Dear Mr Saminaden,
Ref Council Office Extension N6/2013/A33/1411.

I am shocked to learn of the implementation of very questionable plans to extend the present council offices.

Title Proposed Sections

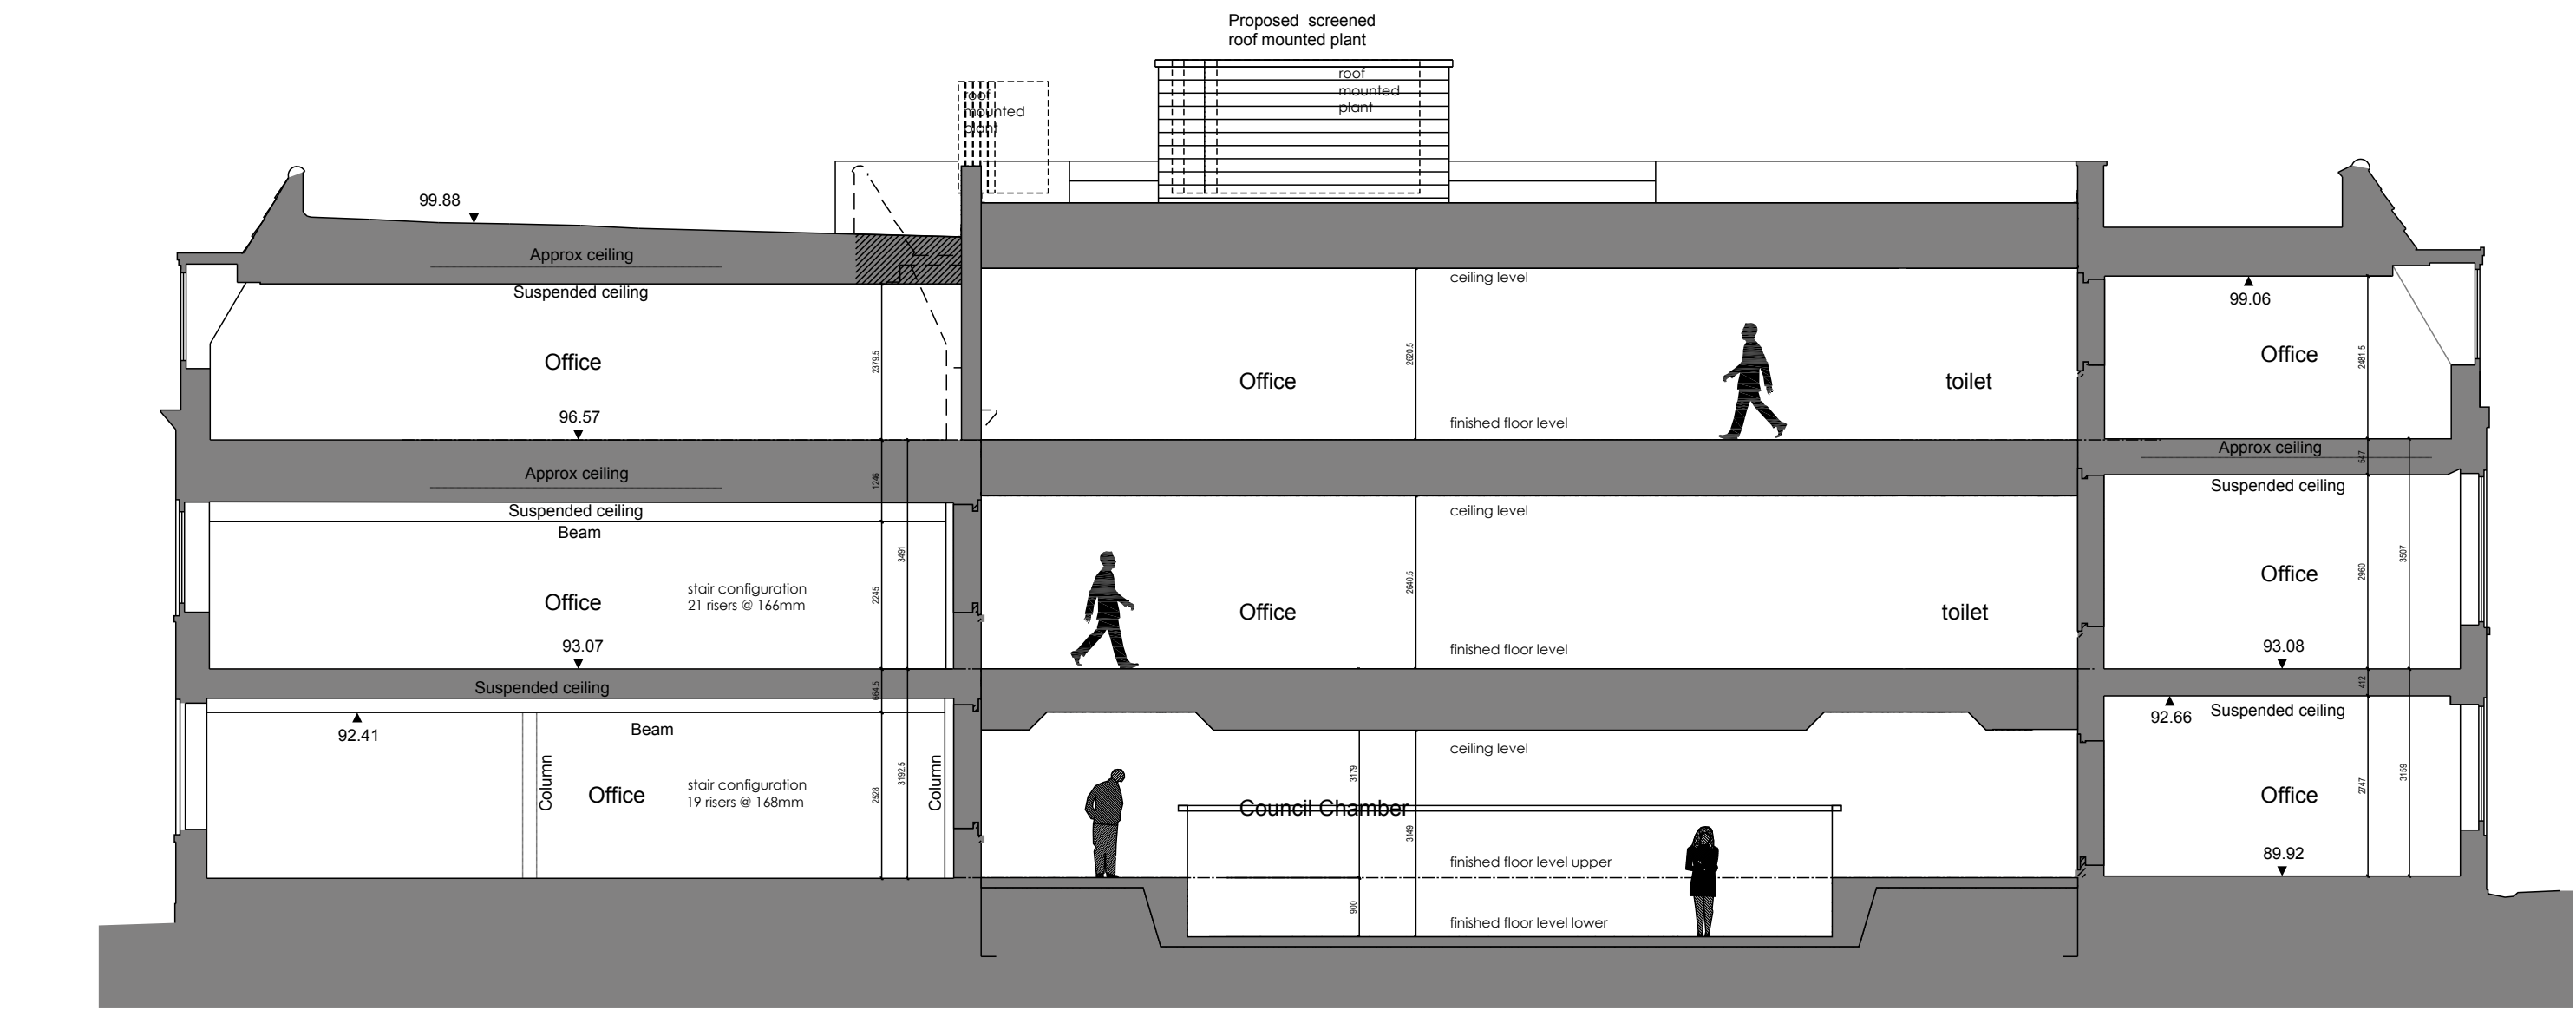
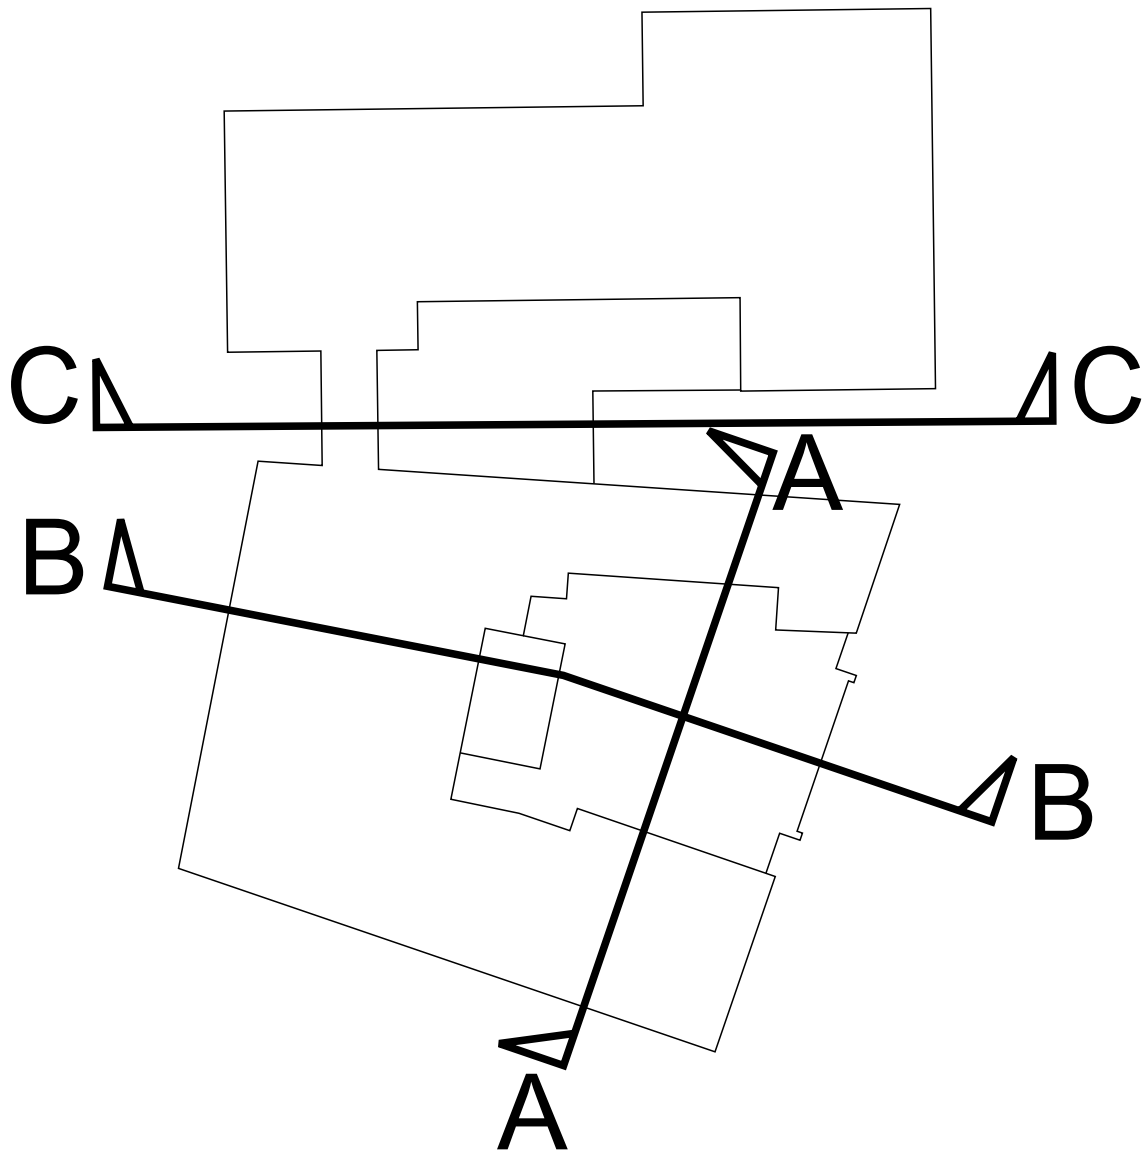
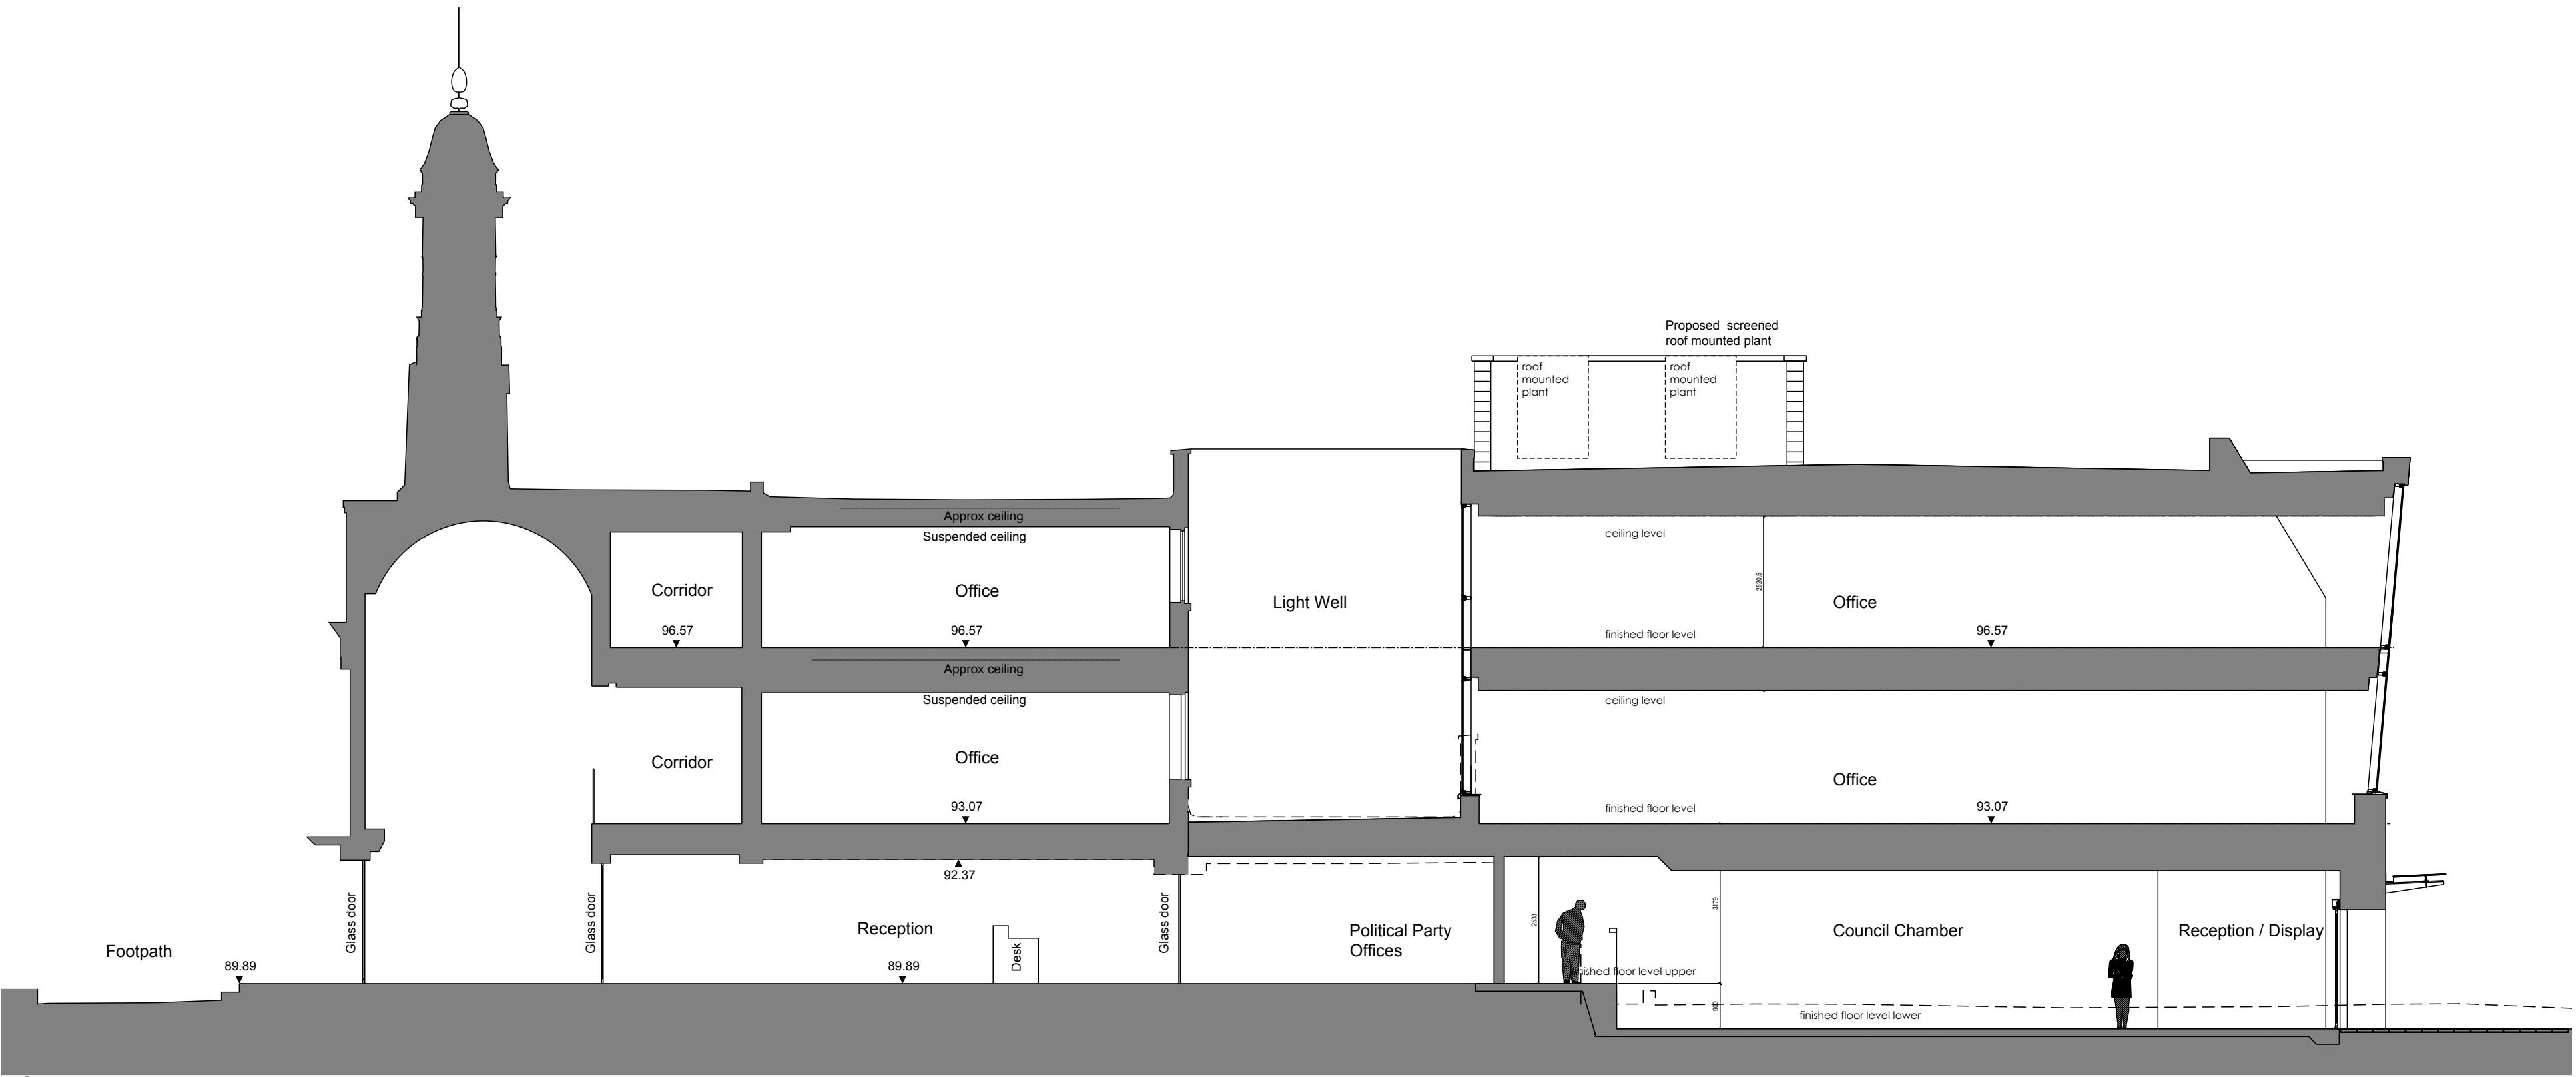
- a) Use of alien materials eg concrete, steel and glass construction versus red brick & tiles
- b) Unacceptable roof line
